Charlotte Department of Transportation

Memorandum

Subject: Rezoning Petition 08-077: Located between North Wendover Road and Billingsley Road at Cascade Circle (revised 5/19/08)

SCHEMATIC SITE PLAN

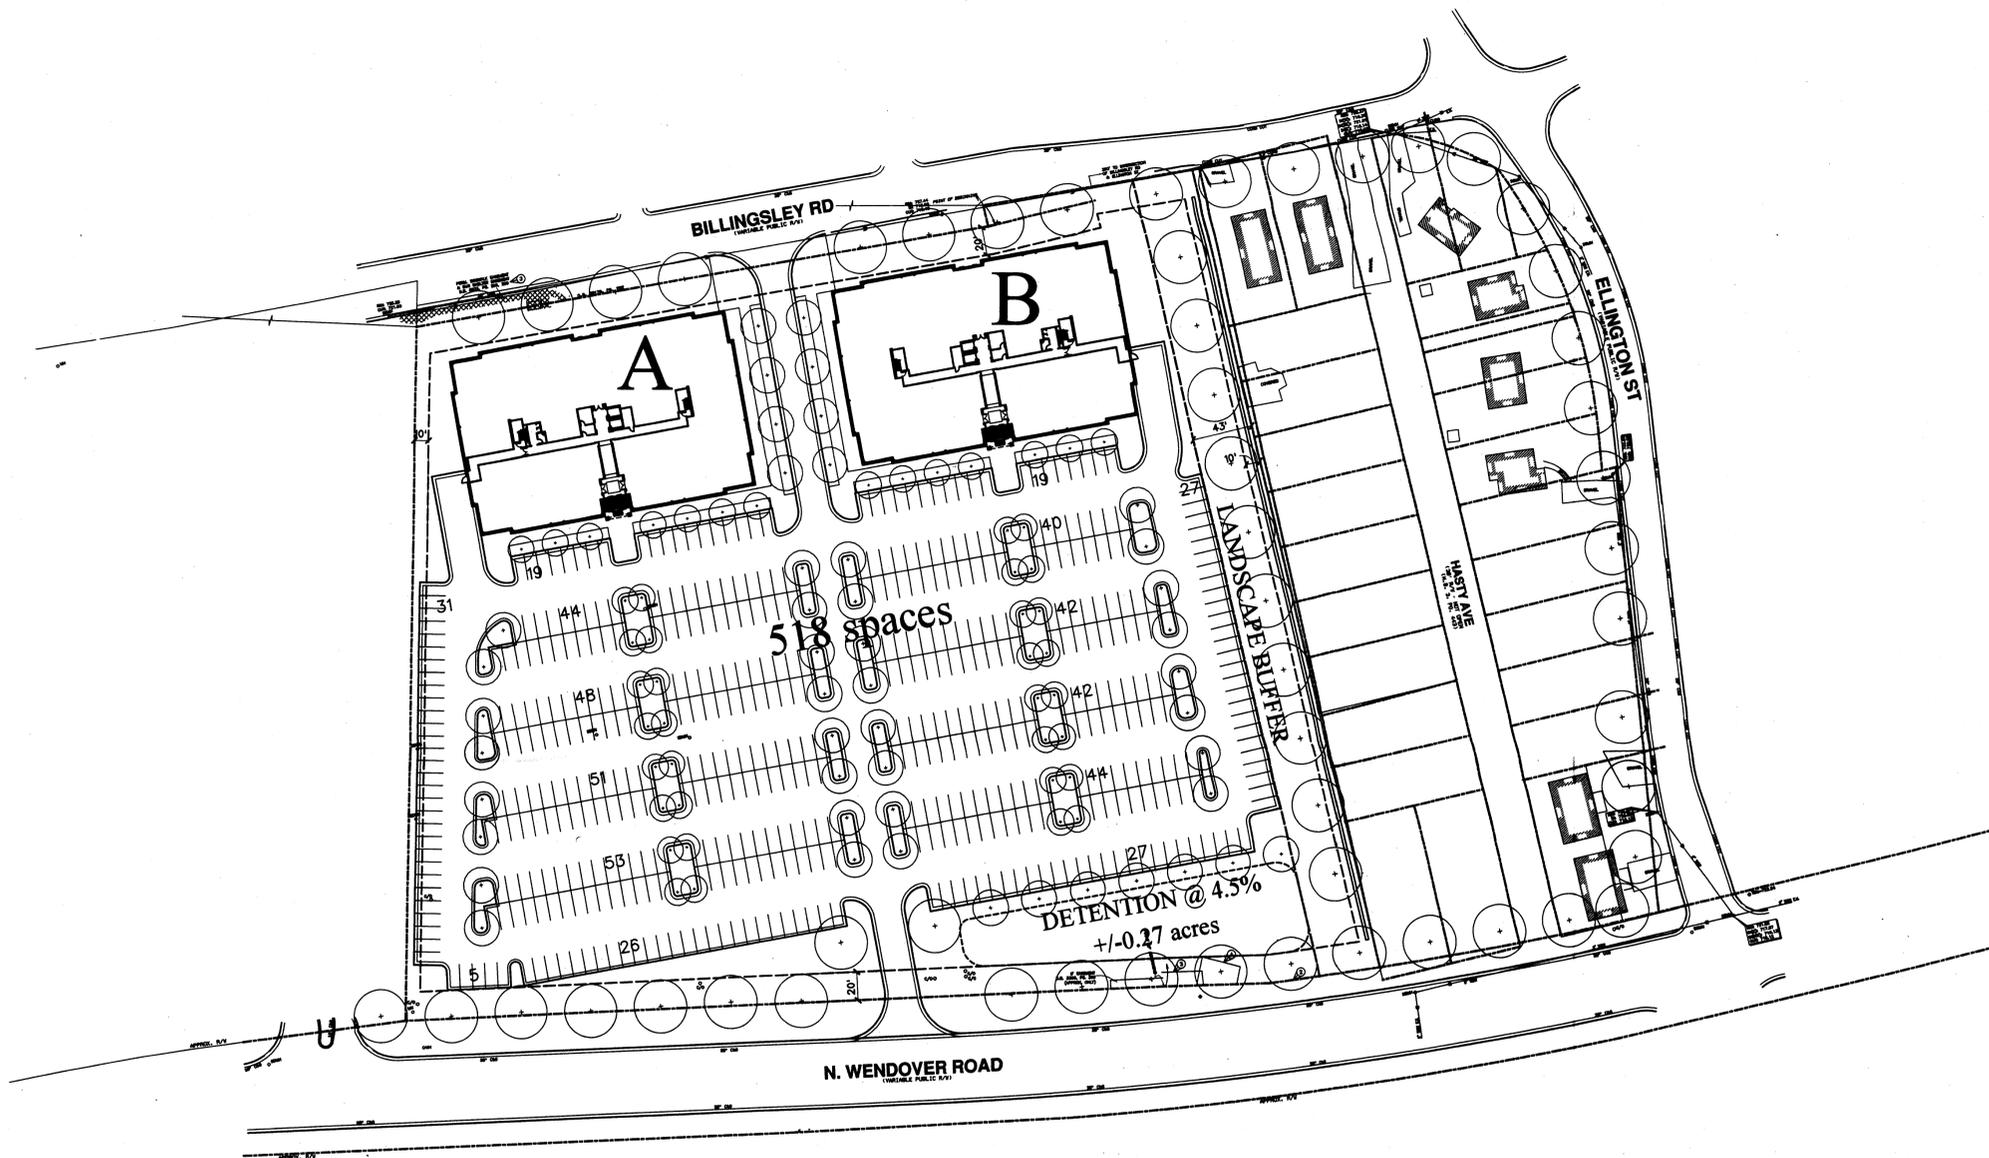
2. CDOT will support only one connection (street or driveway) to Wendover Road to provide access to the site. This access needs to be a public street in the location of the driveway shown at elevation +706 and connect Wendover Road with Billingsley Road. This results in a block spacing of between 400-500 feet with respect to Ellington Street (existing) and the existing Type III-street type entrance to the adjacent property to the west. This is consistent with the City's *Driveway Regulations* and *Urban Street Design Guidelines (USDG)* for this location. Other proposed streets and driveways need to be deleted from the site plan. *(previous review comment)*

3. The public street described above needs to be designed as a Local Commercial Street with planting strips/sidewalks on both sides of the street. The Local Commercial Street (USDG) has a minimum back-of-curb/back-of-curb width of 25 feet for a mixed vehicle zone (if no dedicated on-street parking), 8-foot planting strips, and 5-foot sidewalks. For recessed parallel parking, add 14 feet to the street cross section. *(previous review comment)*

4. We can support the extension of proposed Street C (public or private) to connect internally with the public street described above.
5. Due to the size of the development and the expected traffic volumes, driveways on the public street described in comment 2 will not be approved within 100 feet of Wendover Road (measured from the corner radius curb return). The site plan needs to be revised accordingly.

6. CDOT will support parallel parking on the proposed public streets. We do not support the use of angled parking because it creates a wider street/setbacks.

7. Wendover Road is a major thoroughfare requiring a minimum of 100 feet of right-of-way. The developer/petitioner should convey right-of-way in fee simple title to meet this requirement, measuring 50 feet from the centerline of the roadway.

8. North Wendover Road is a state maintained road. The NCDOT may require a left and/or right-turn lane at the connection to North Wendover Road whether it is a new public street or a new driveway connection. The petitioner may contact Louis Mitchell, NCDOT District Engineer at 704.596.6900 to determine whether turns lanes will be required.
